WEST SUSSEX COUNTY COUNCIL CONSULTATION

TO:	Arun District Council FAO:David Easton
FROM:	WSCC - Highways Authority
DATE:	19 October 2021
LOCATION:	Oldlands Farm Cottages Steyning Way Bersted PO22 9NN
SUBJECT:	BE/145/21/DOC Approval of details reserved by condition imposed under ref BE/126/19/PL relating to Condition Nos 4 - hard & soft landscaping, 5 - pedestrian link/cycle link, 9 - Travel Plan and 13 - electric vehicle charging.
DATE OF SITE VISIT:	n/a
RECOMMENDATION:	Advice
S106 CONTRIBUTION TOTAL:	n/a

Project BBS 2020.2 Lidl Corporate Specification				
Drawing Title Electric Charging Point Details				
Project No. 07630	Drawing No. LD(14)-SP-09	Suitability INFO	Revision 01	Scale at A1 As indicated
File Reference: 07630-SPACE-LD(14)-SP-09-INFO-01

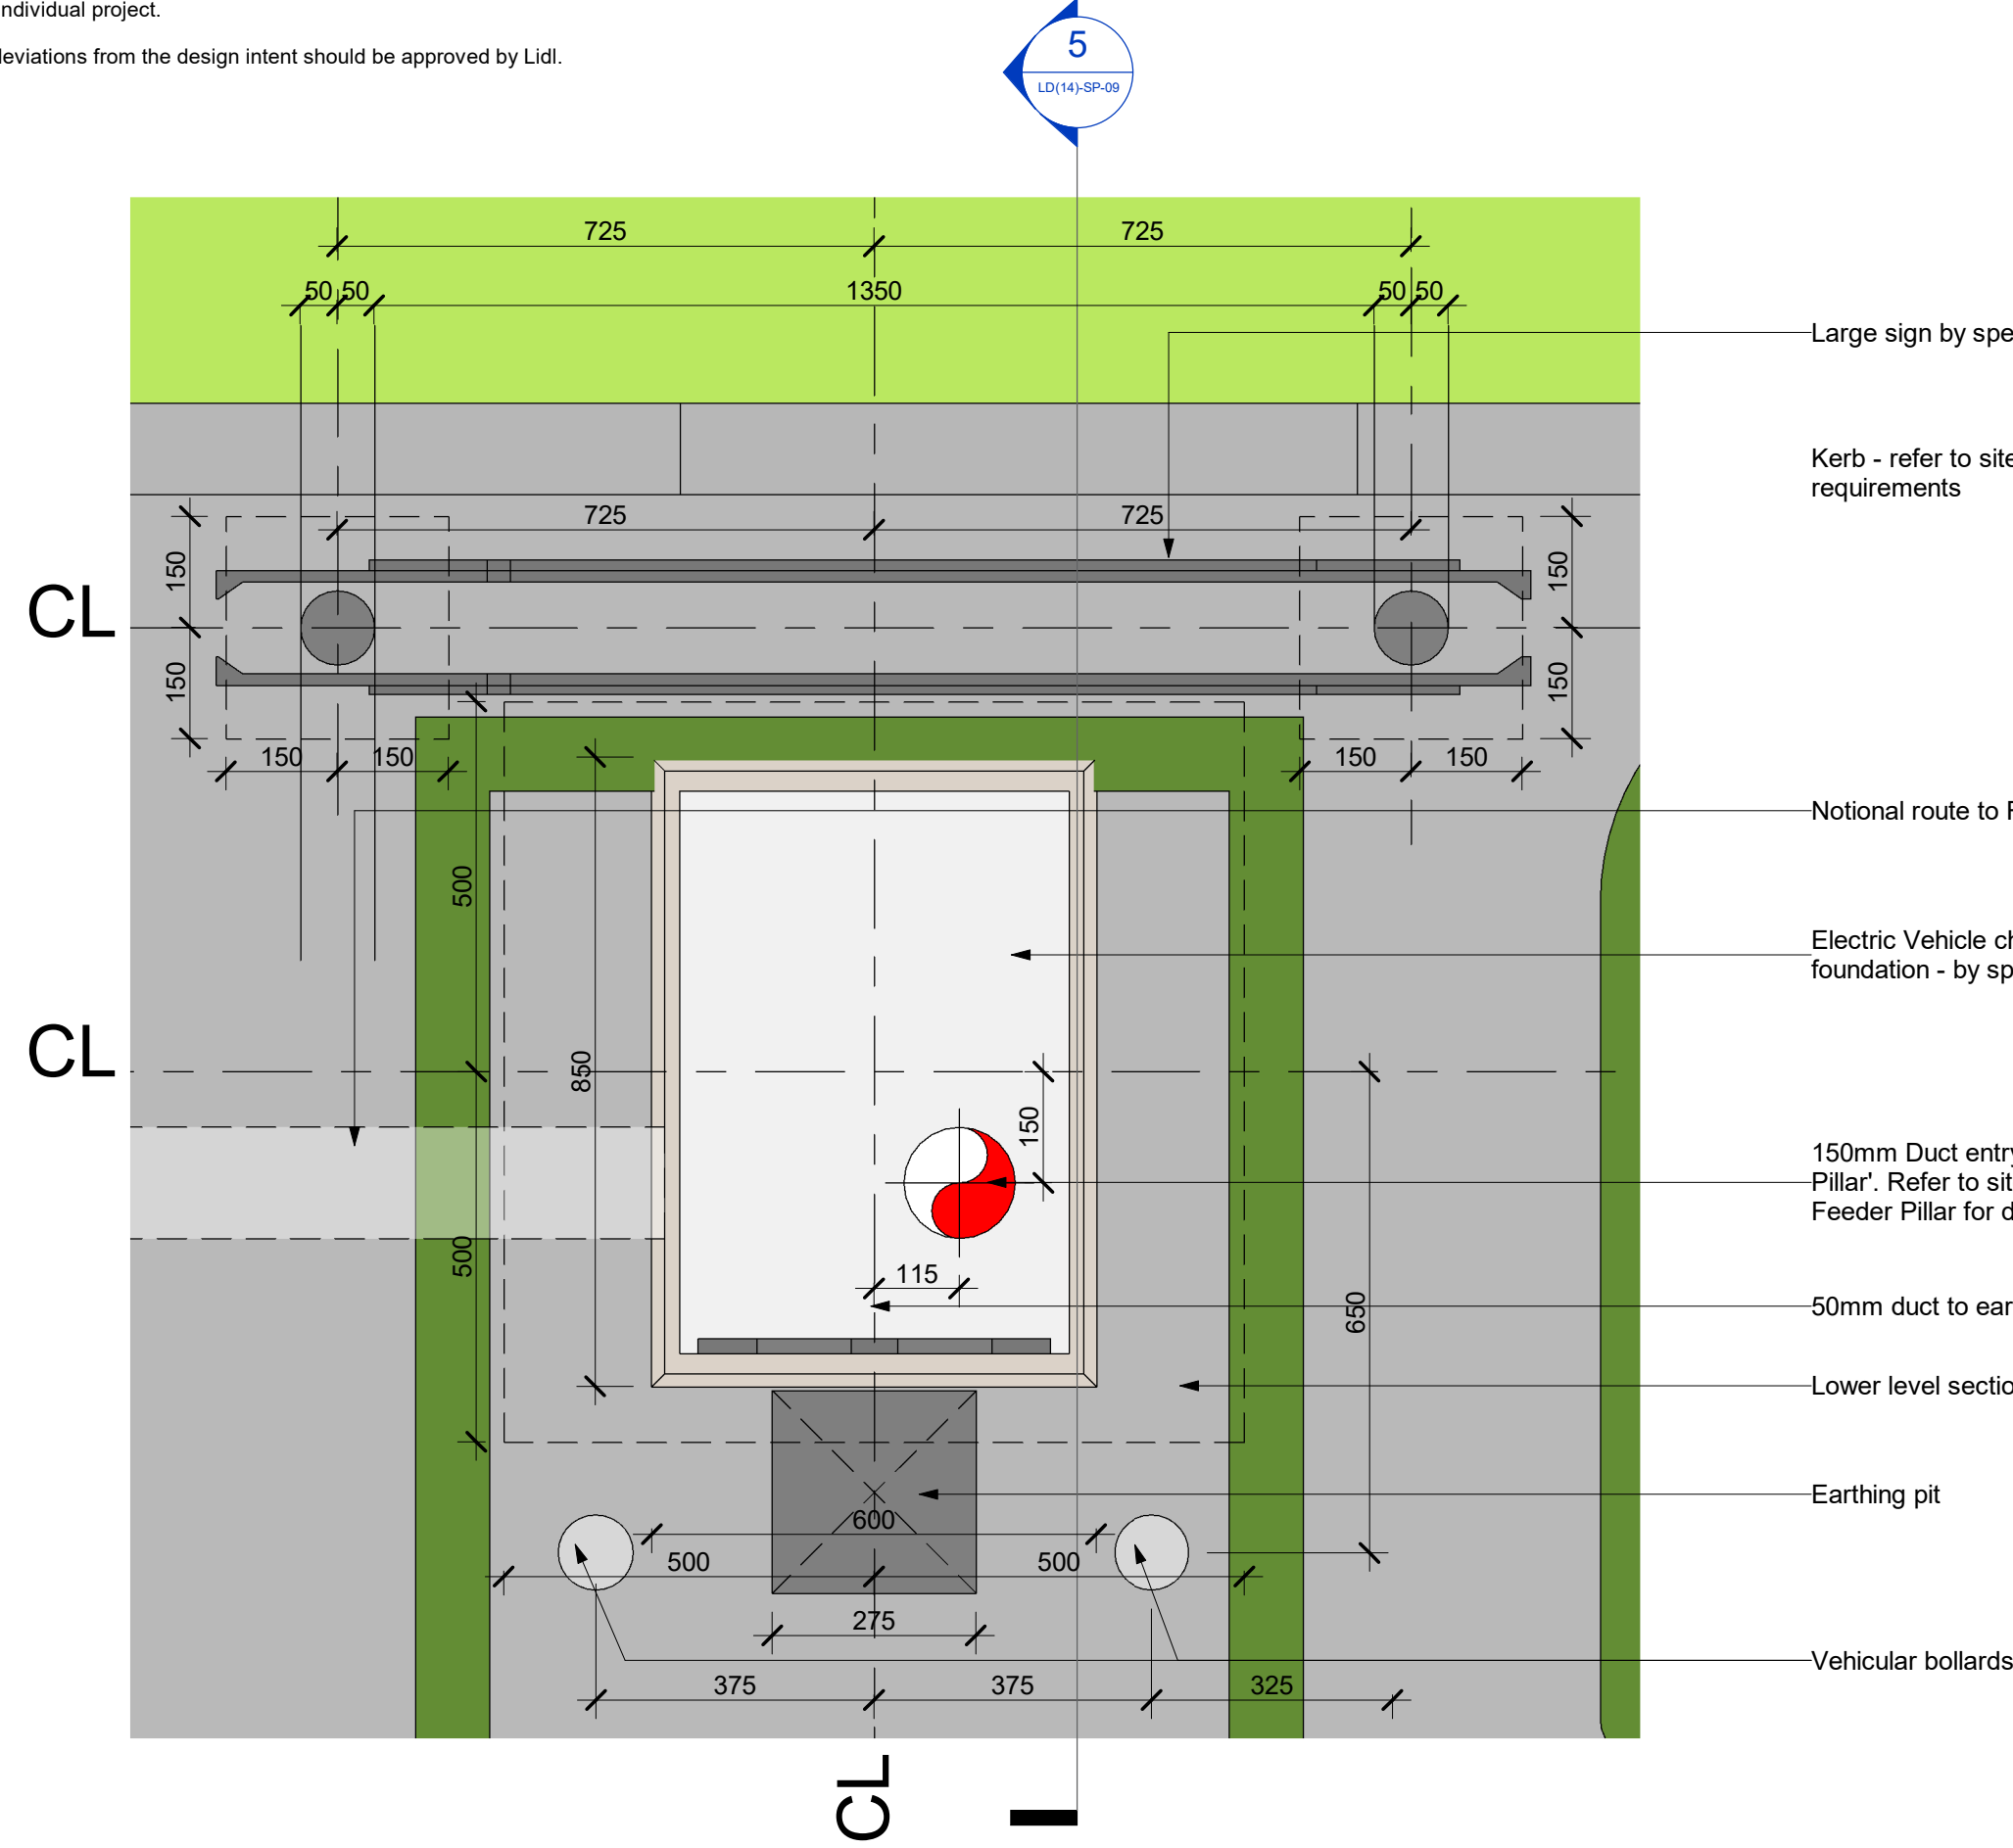
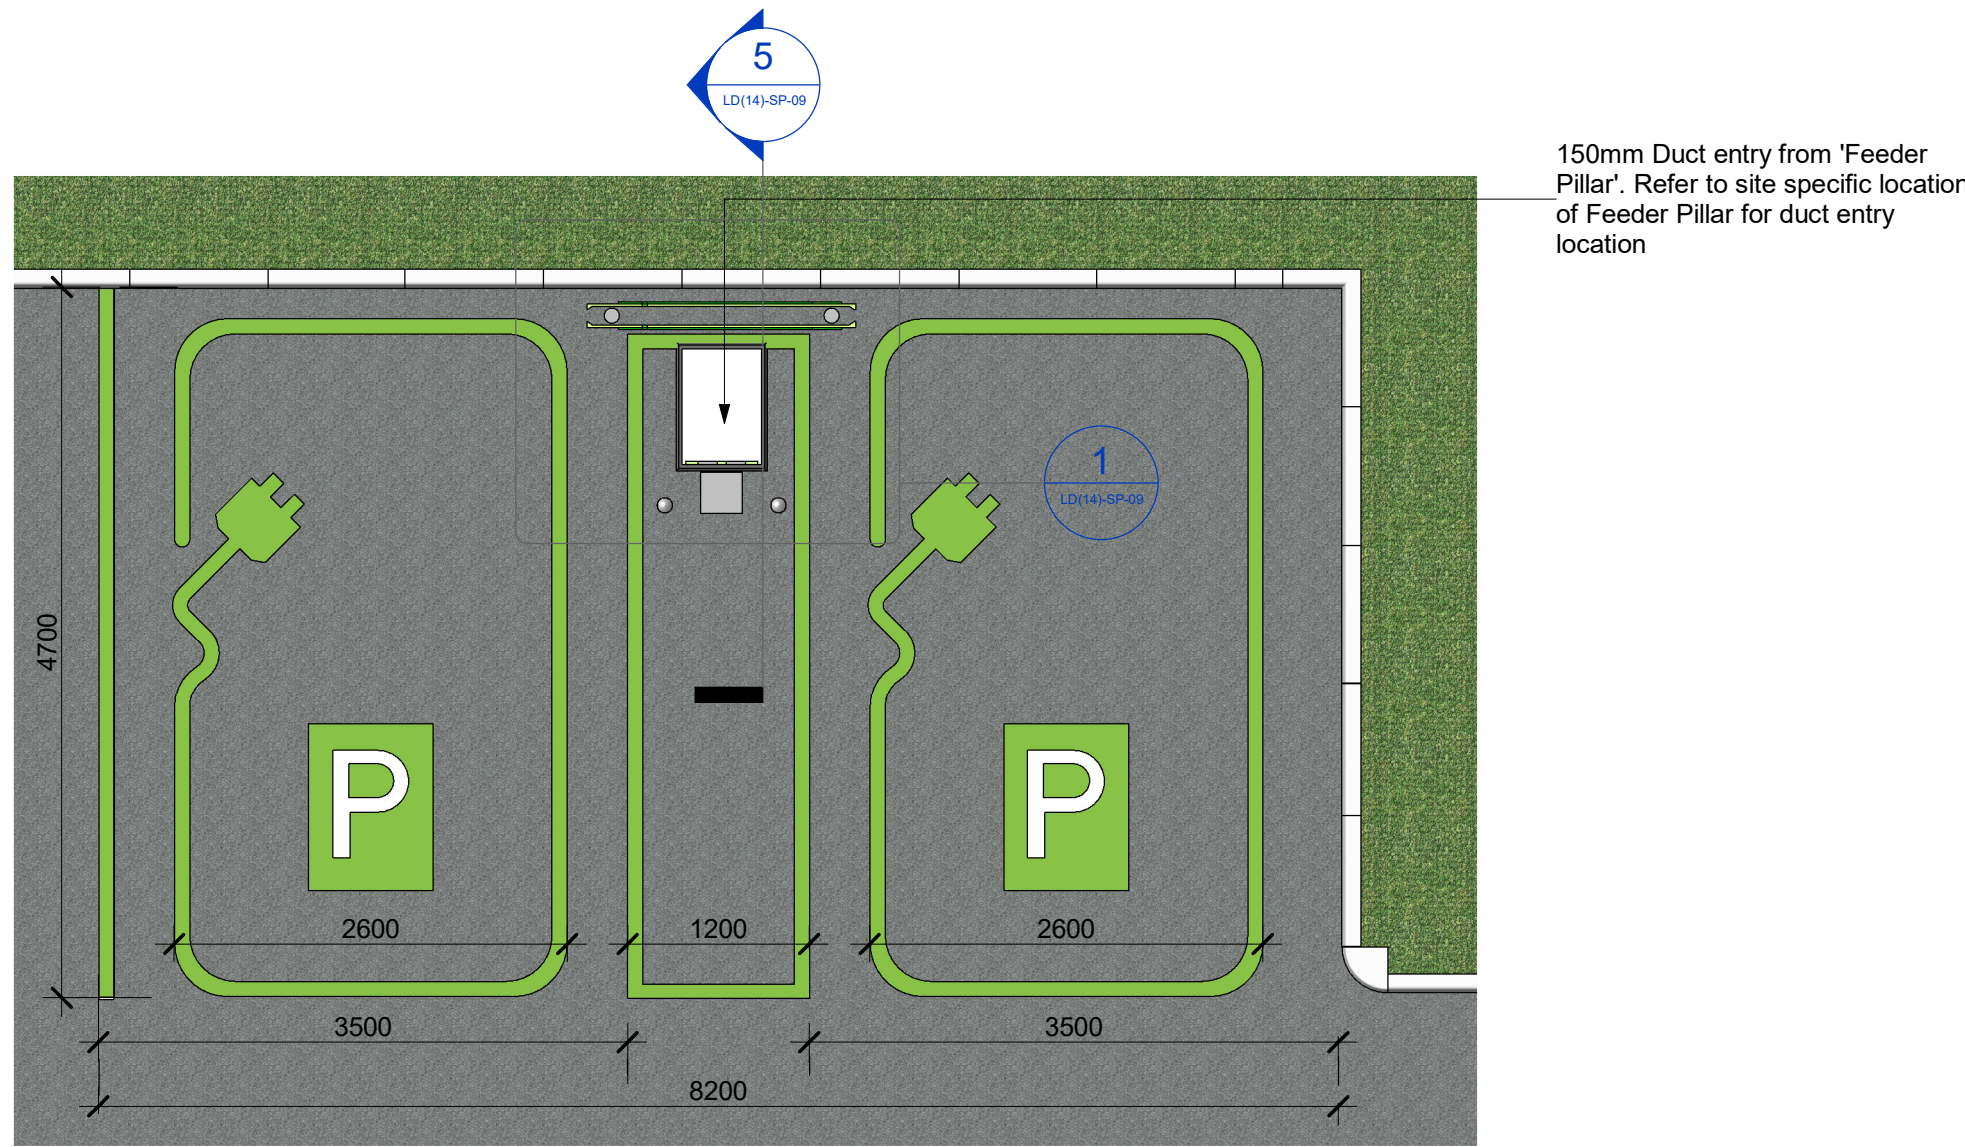
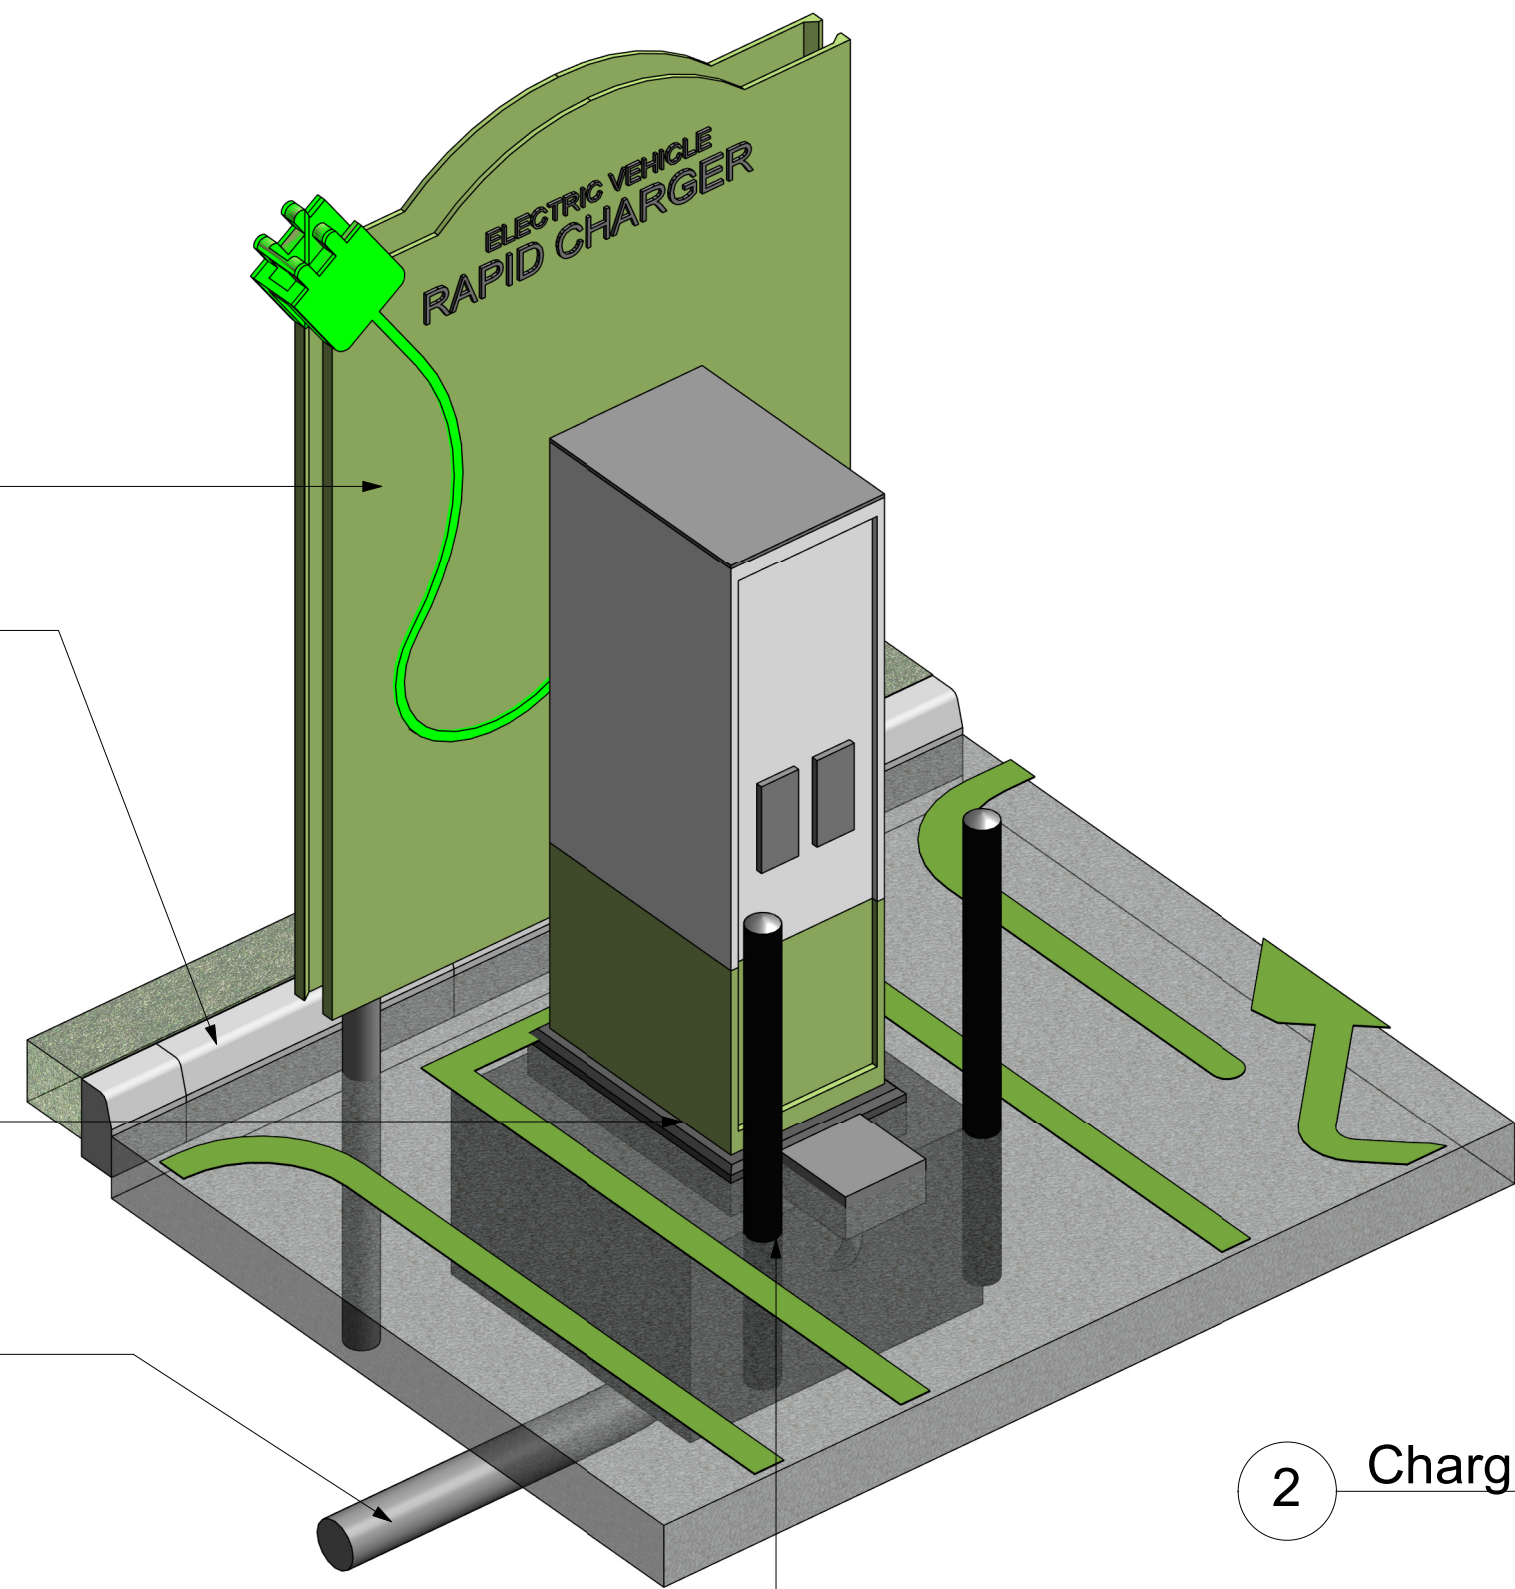
Condition 13-The LHA would be satisfied with the proposed allocation of Electric Vehicle charging points at the site.
